24 November 2020

Weigall Sports Complex, Sydney Grammar School  
Application No SSD-10421  
Objection

Drawing Title
BUILDING 01
SPORTS FACILITIES BUILDING
GENERAL ARRANGEMENT PLAN
GROUND

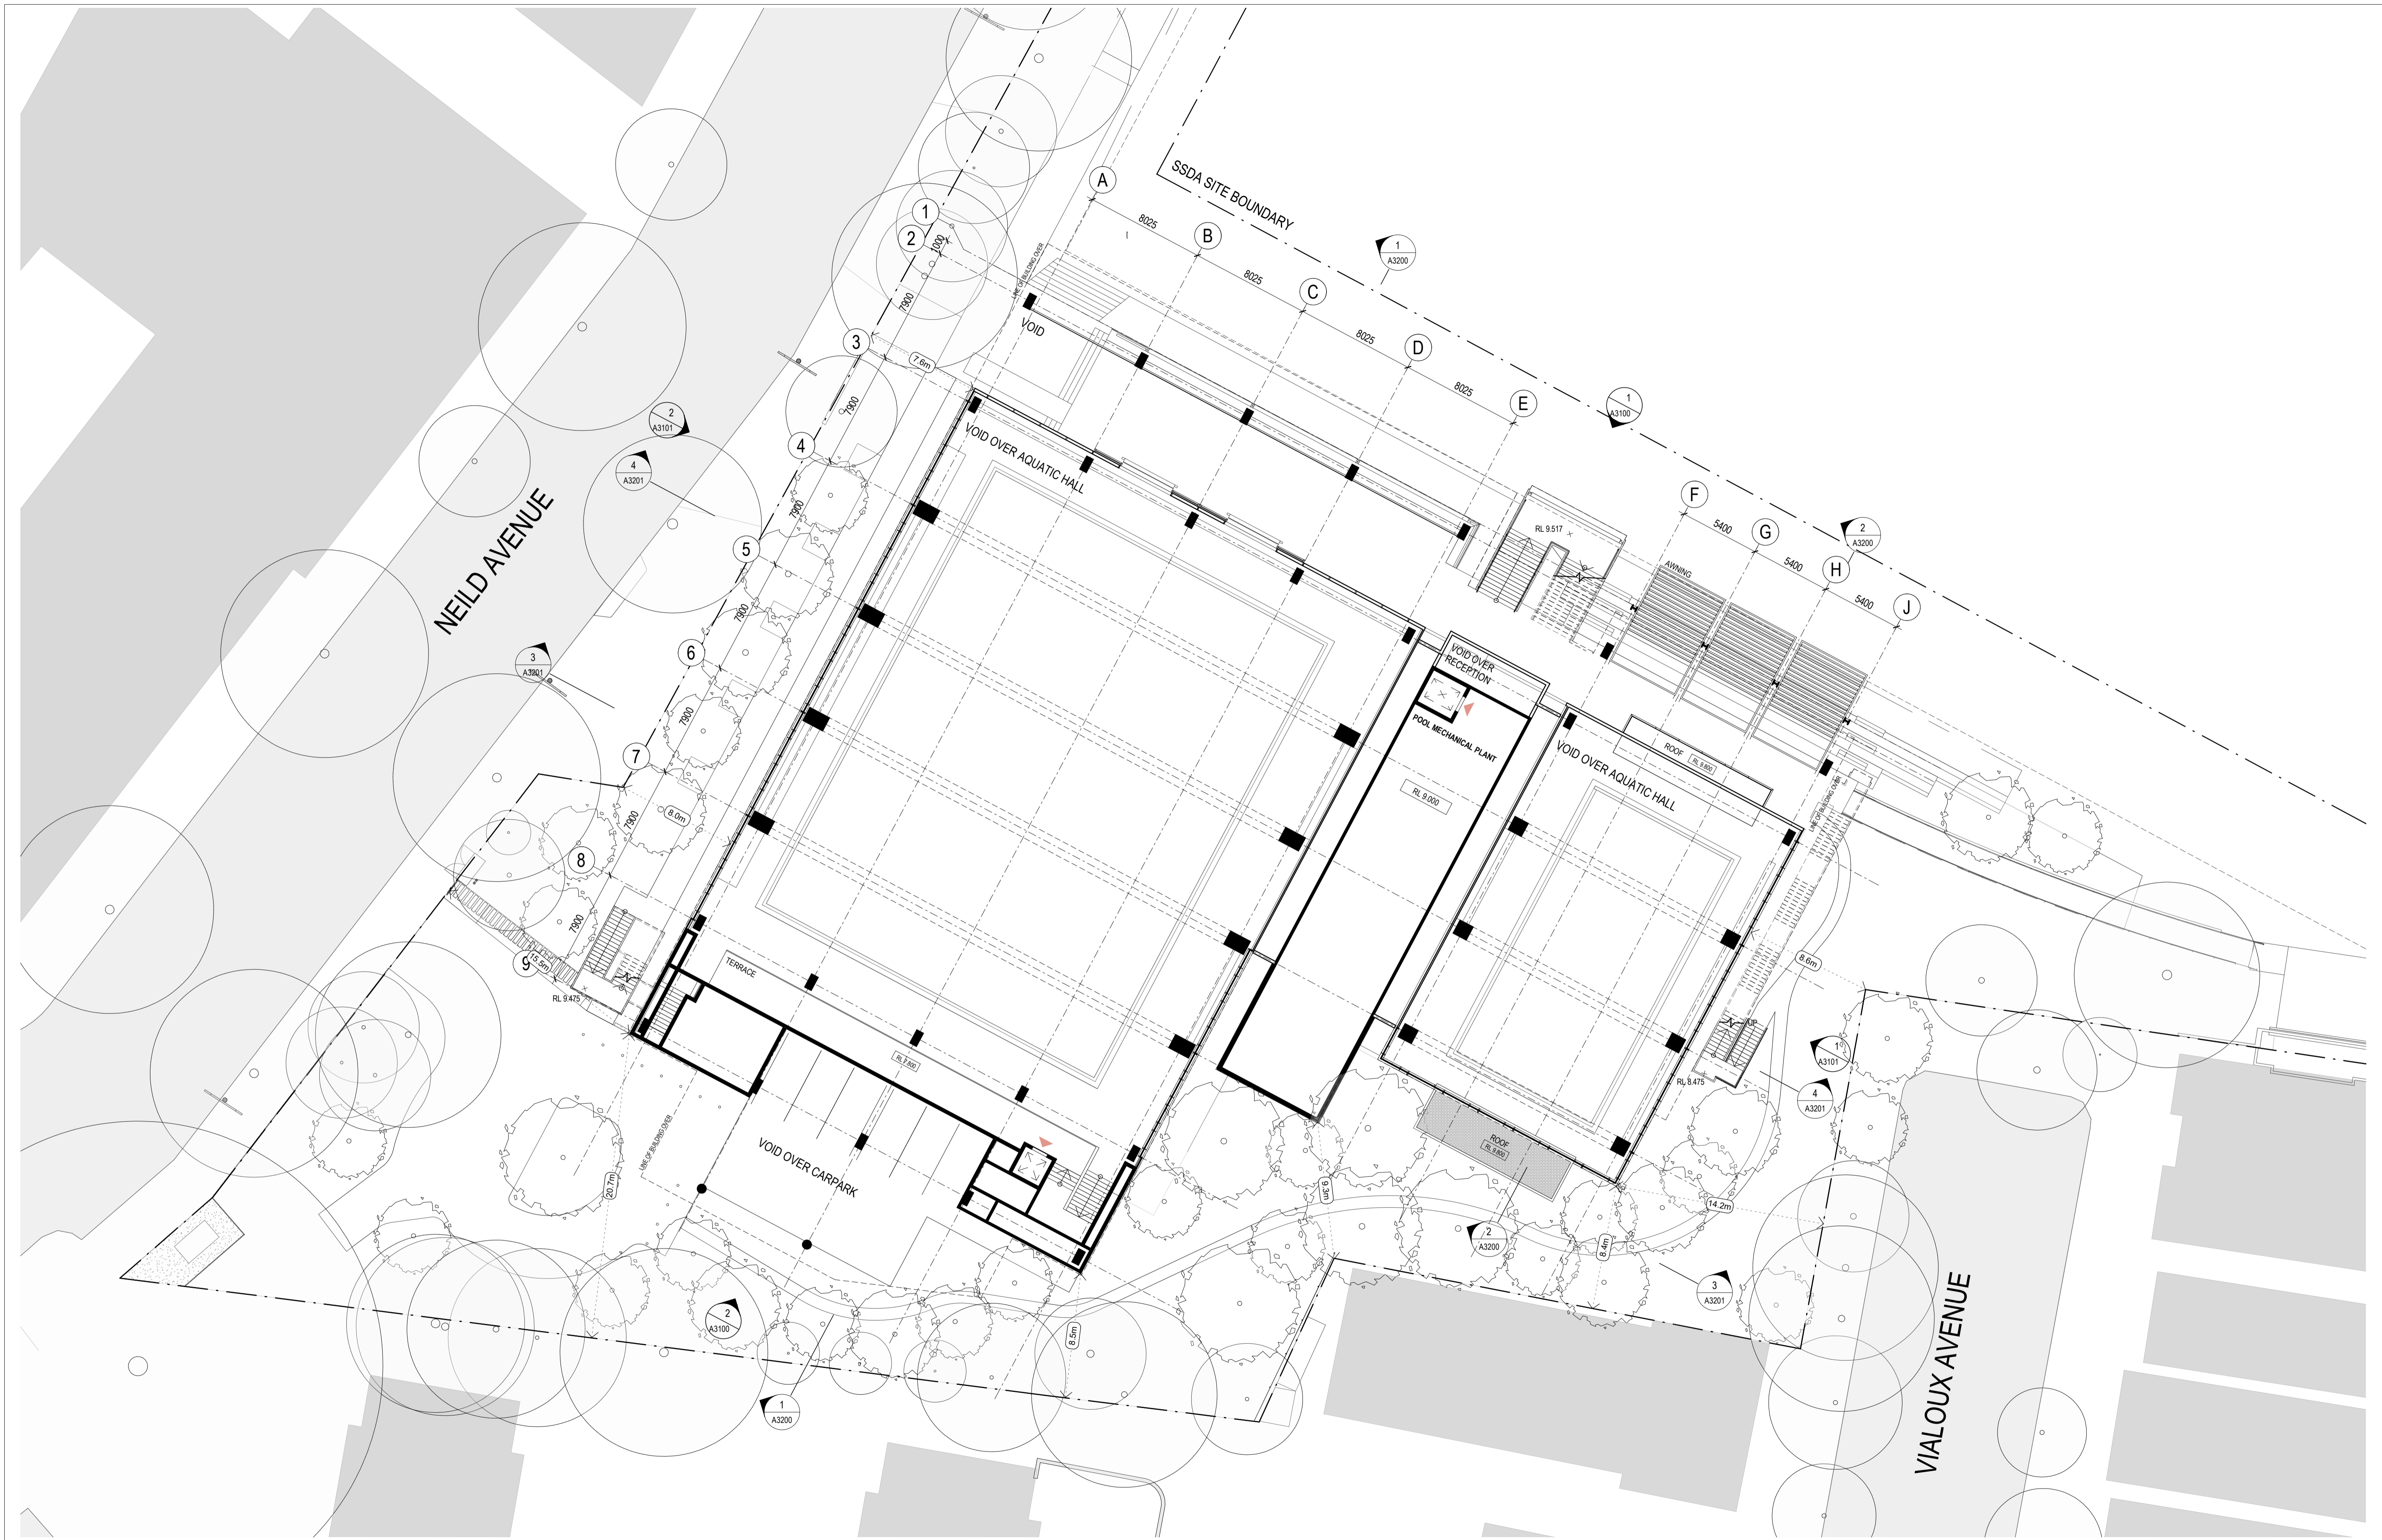
- By way of example a dedicated pickup and drop-off facility proposal within Building 1 car park on Neild Avenue for use by up to an *additional 55 private cars* per day before and after school. The majority of these movements are expected within two 30 minute windows.

- The pickup and drop off facility will be located further south in comparison to the existing Neild Avenue driveway. Given its location further south, vehicles re-entering Neild Avenue from the pickup/drop off facility will have difficulty turning right into Boundary Street and McLachlan Avenue to connect with New South Head Road - an expected source and destination for much of the Weigall Sports Complex private traffic.

- Additionally no plan is evident for pedestrians to safely cross the dedicated pickup and drop-off facility on Neild Avenue footpath on the eastern side.
